June 6, 2023

JN 22007

Subject: **Review of Revised Plans**
Proposed New Residence
6950 Southeast Maker Street
Mercer Island, Washington

TEMPORARY SHORING PLAN
SCALE: 1/4" = 1'-0"

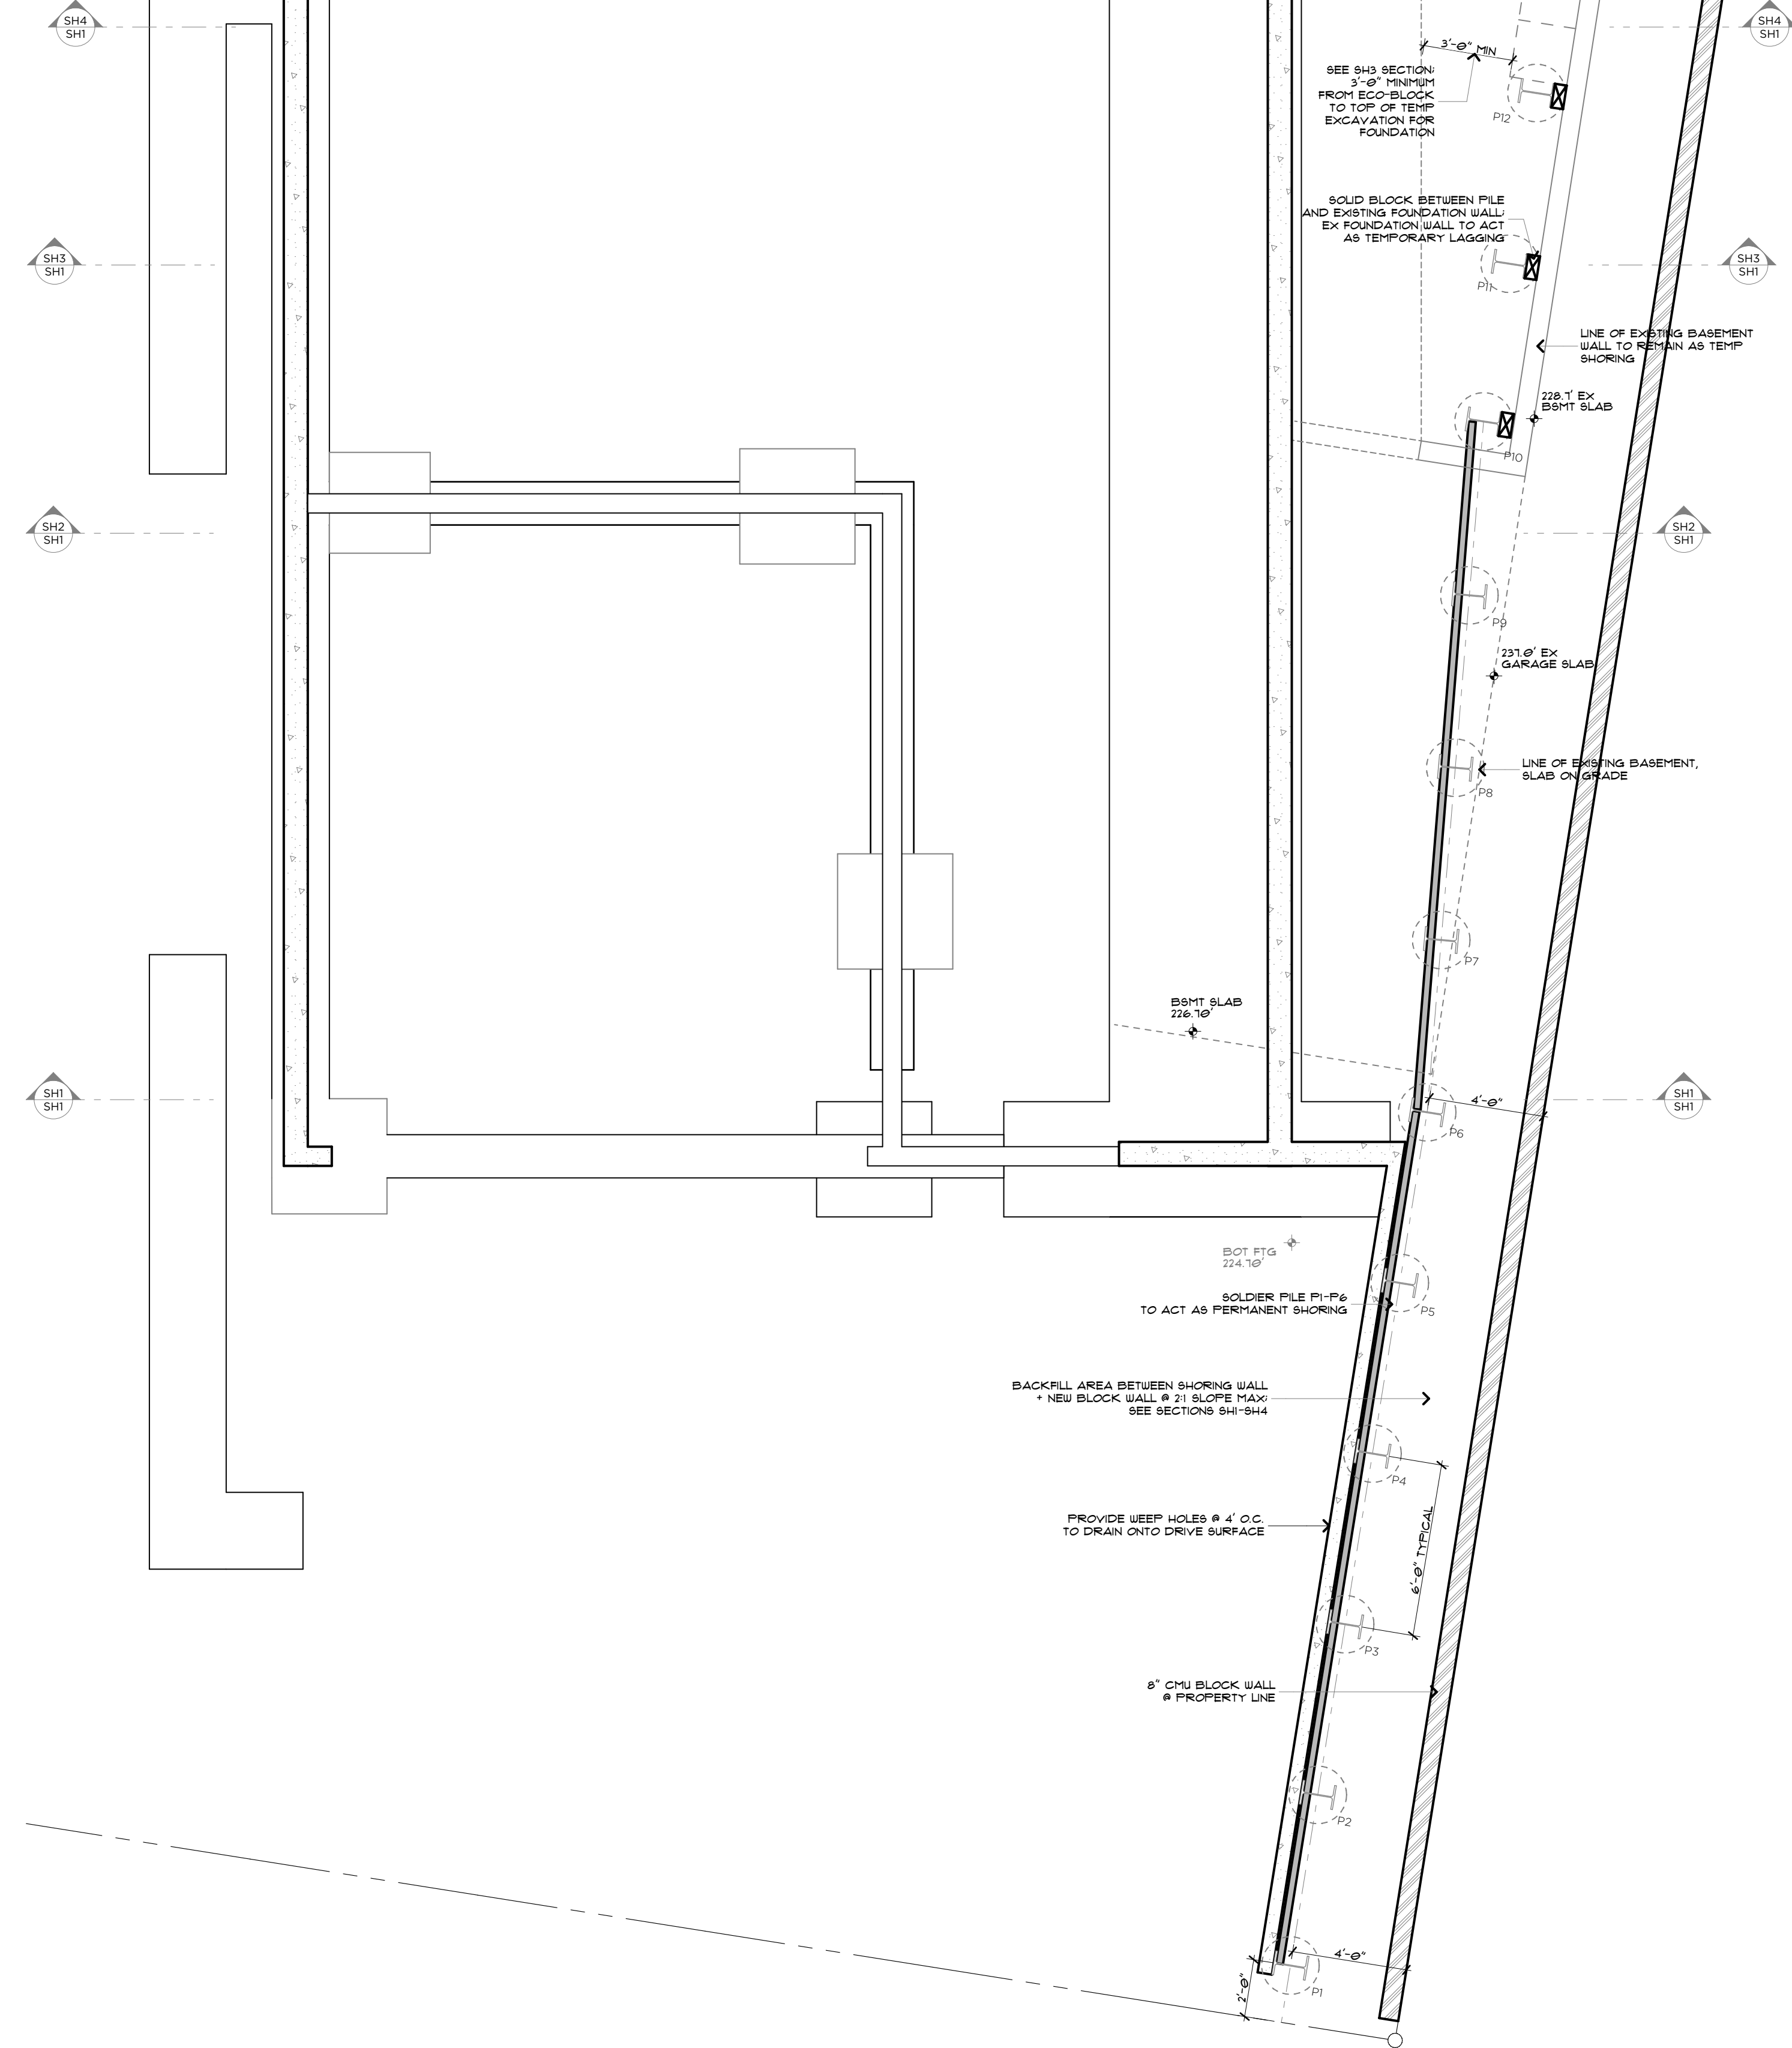
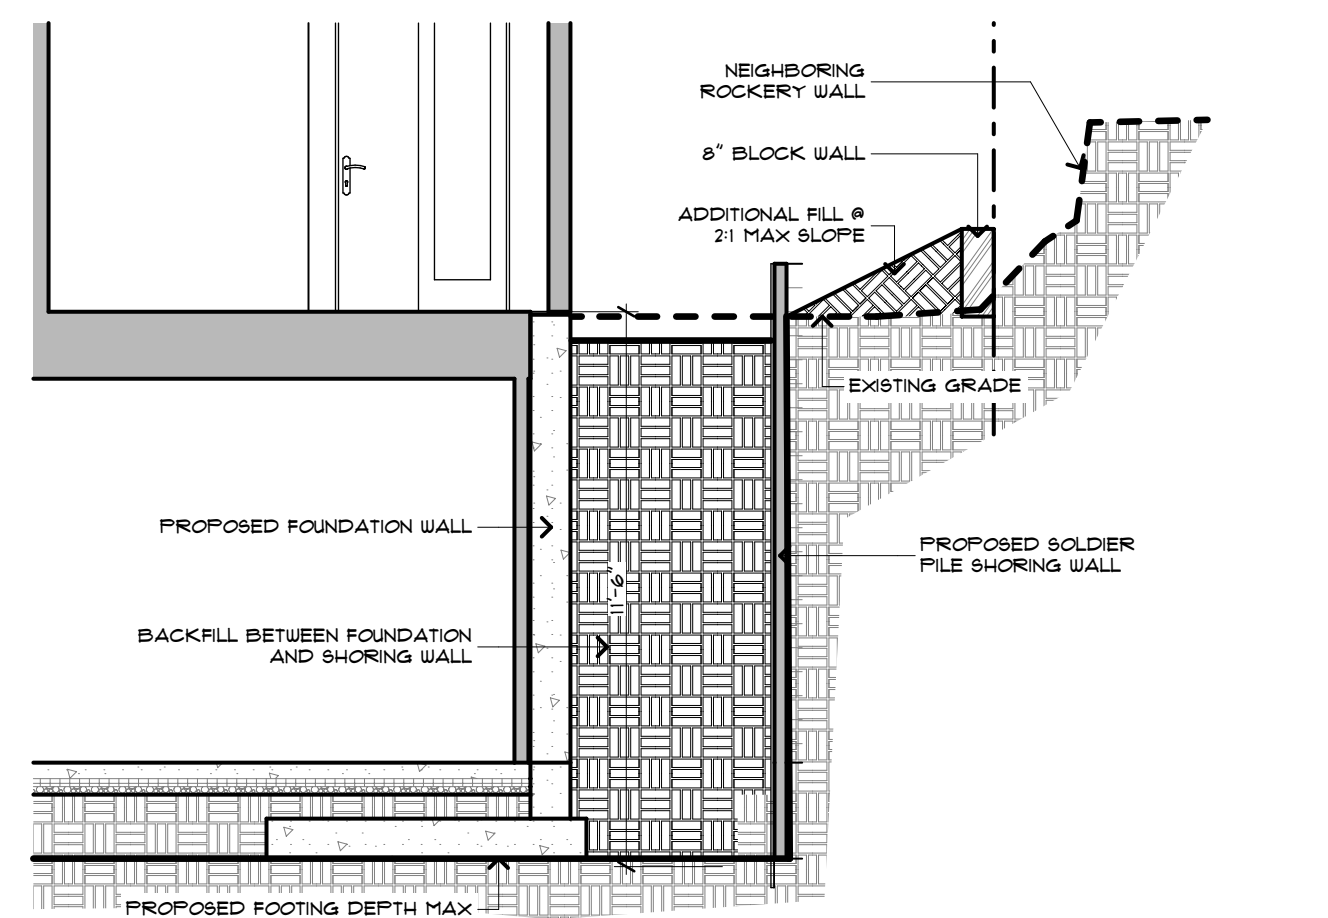
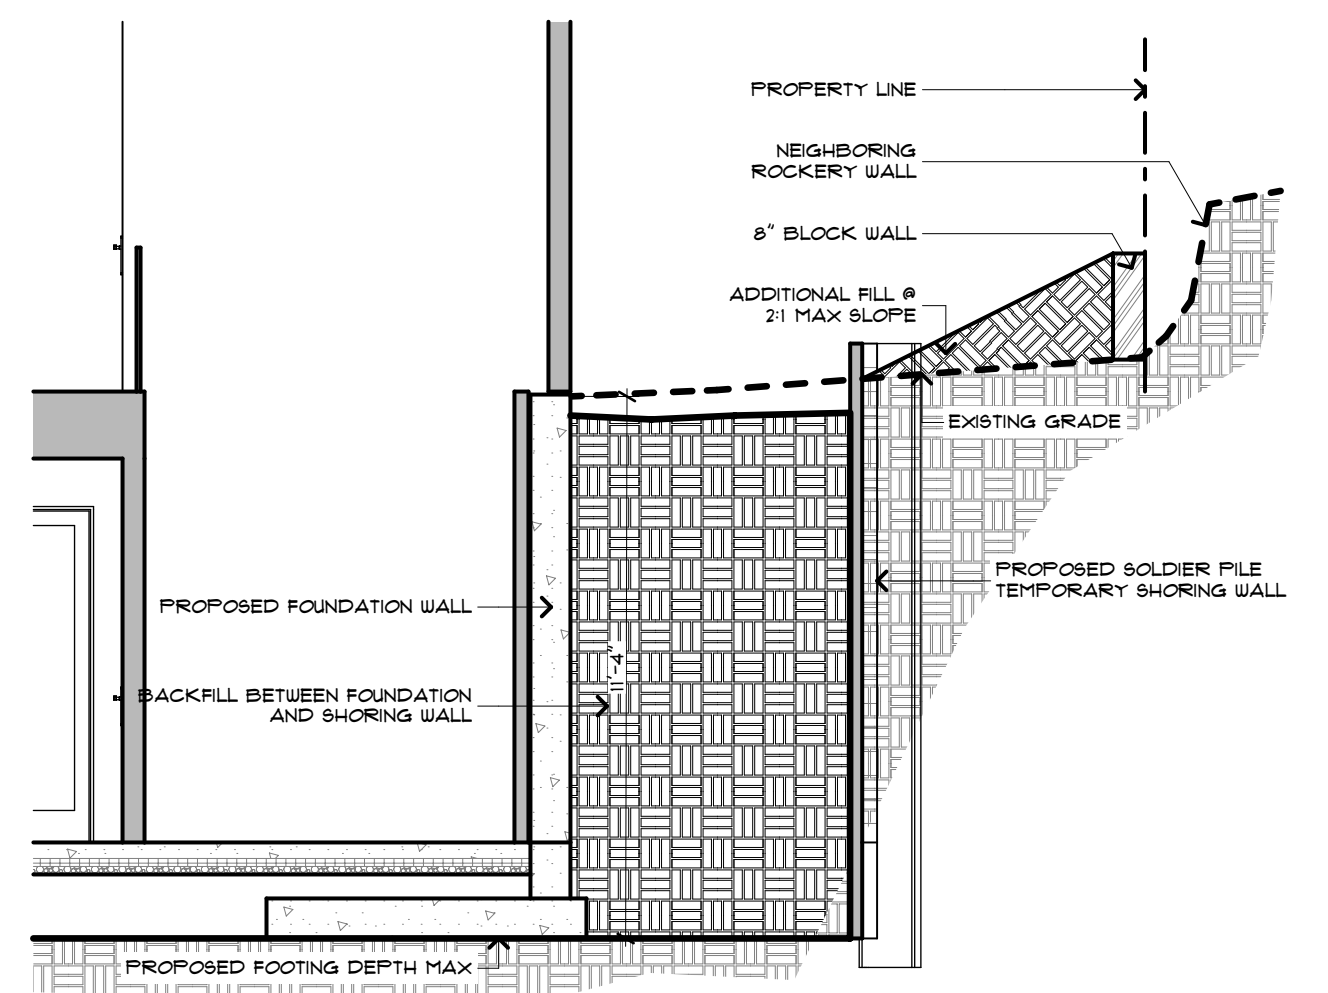
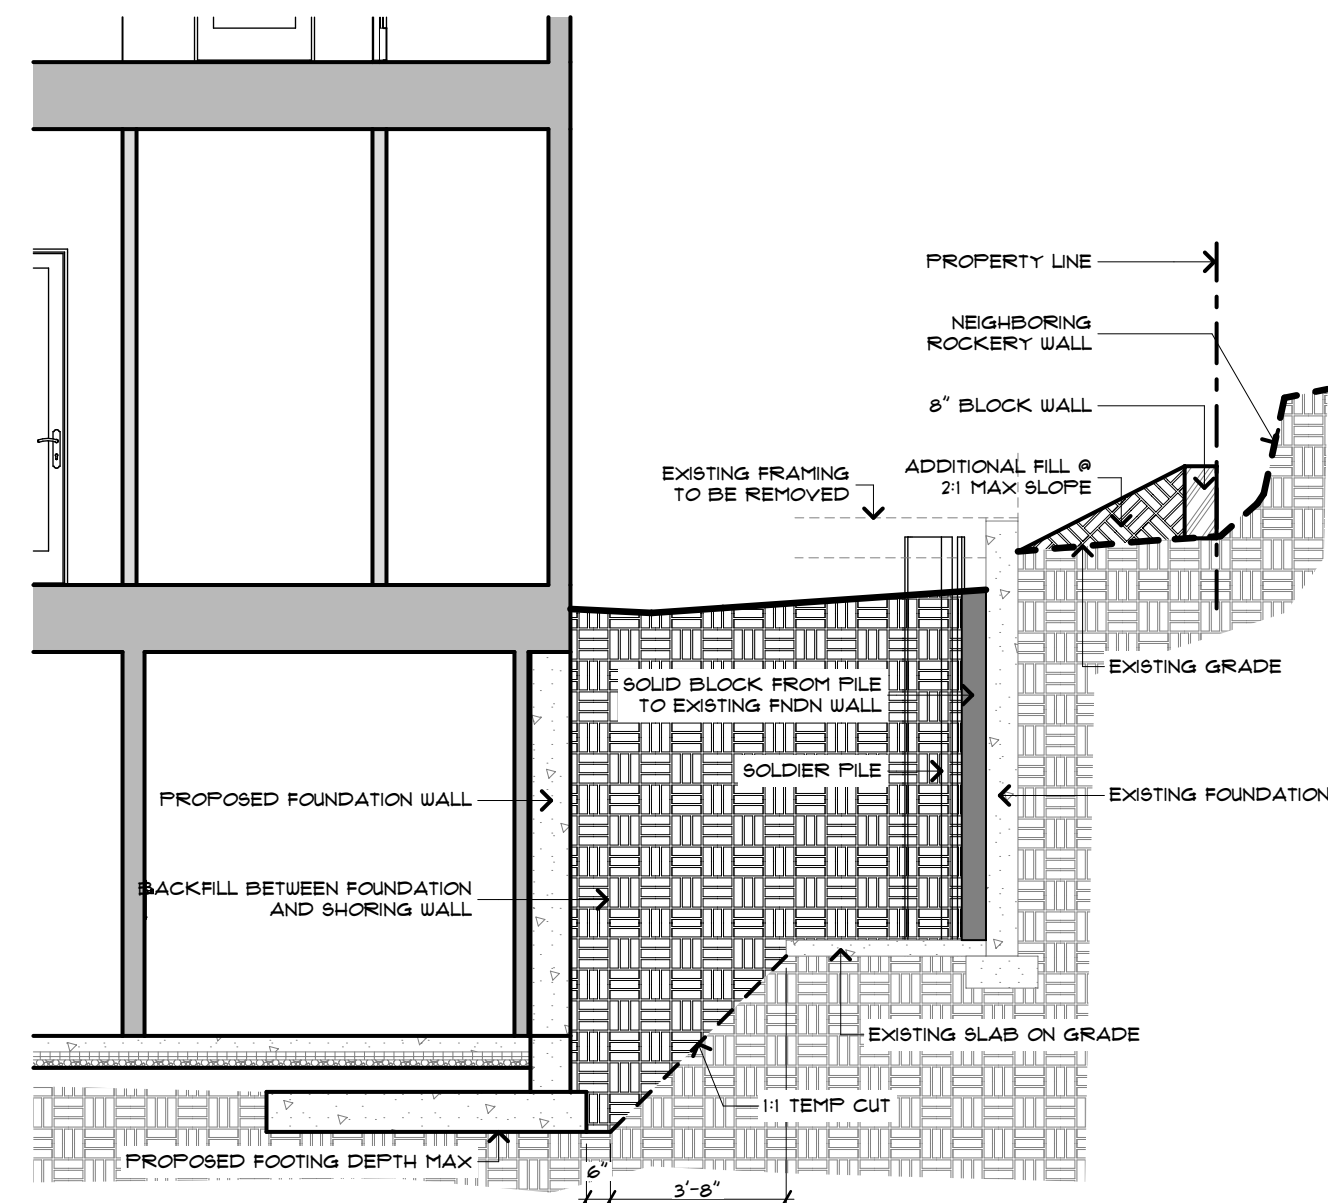
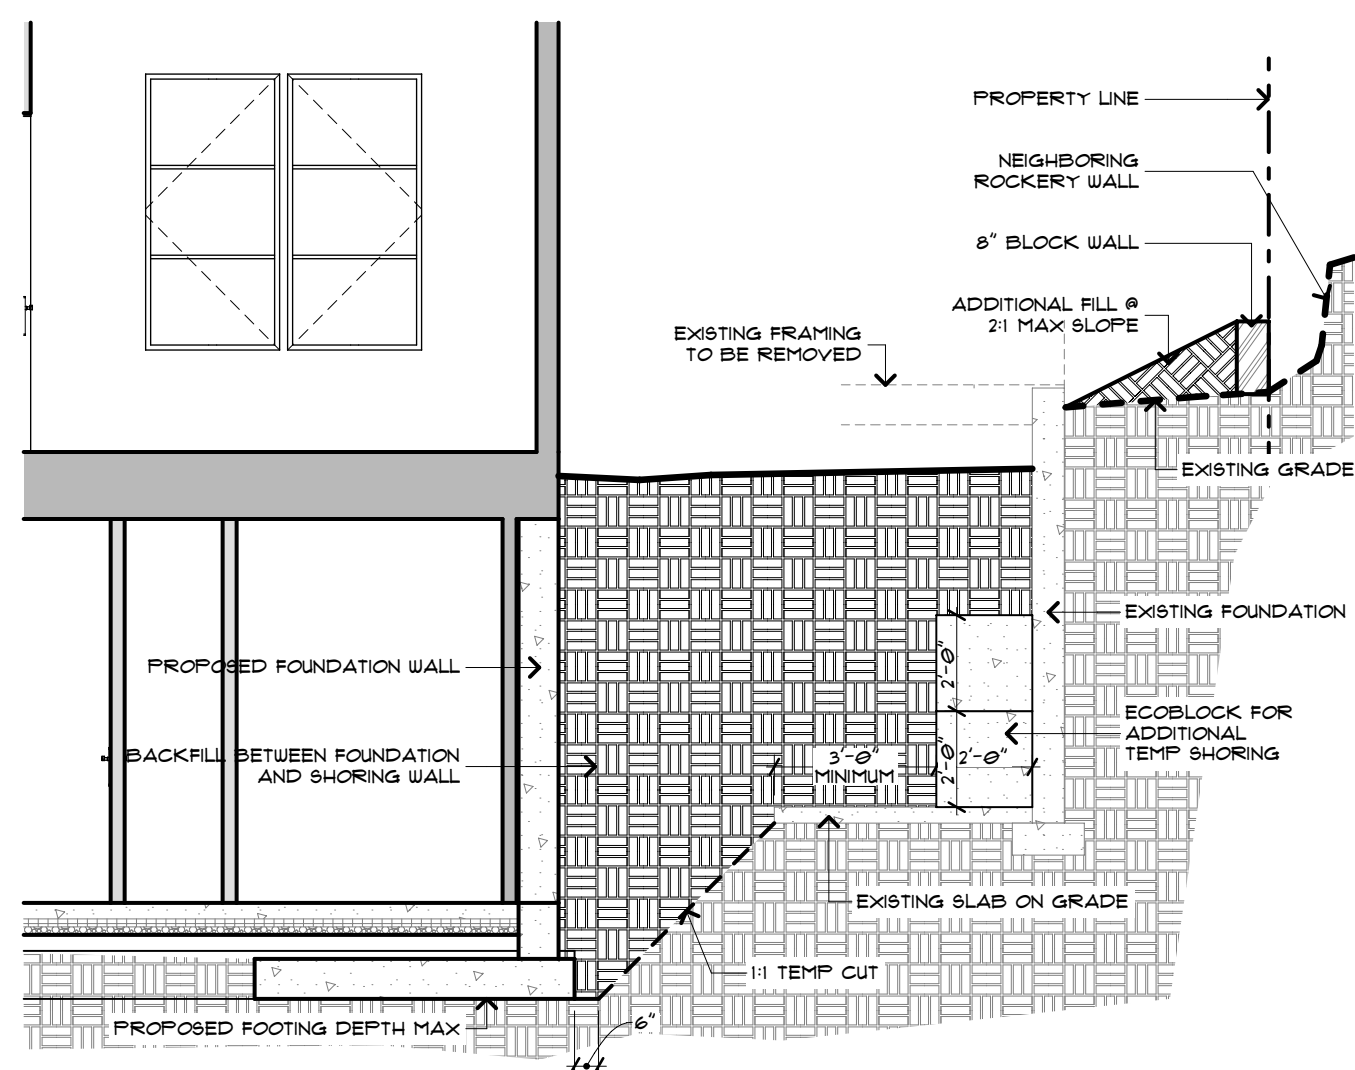
The shoring (SH) drawings correctly depict the partial removal of the existing western rockery, combined with the installation of closely-spaced soldier piles immediately behind the remaining lower portion of the rockery. The remaining lower approximately 5 feet of the rockery will no longer have to resist any lateral soil load, as this will be accomplished by the stabilization piles. This

system incorporates our recommendations to provide stability for the existing fill located on the west side of the lot.

The Site Plan and sections on SH1, as well as sheets C-2 and C-3, properly illustrate the fill berm and modular block wall to be constructed as protection against a potential failure of the eastern neighbor's modular block wall.
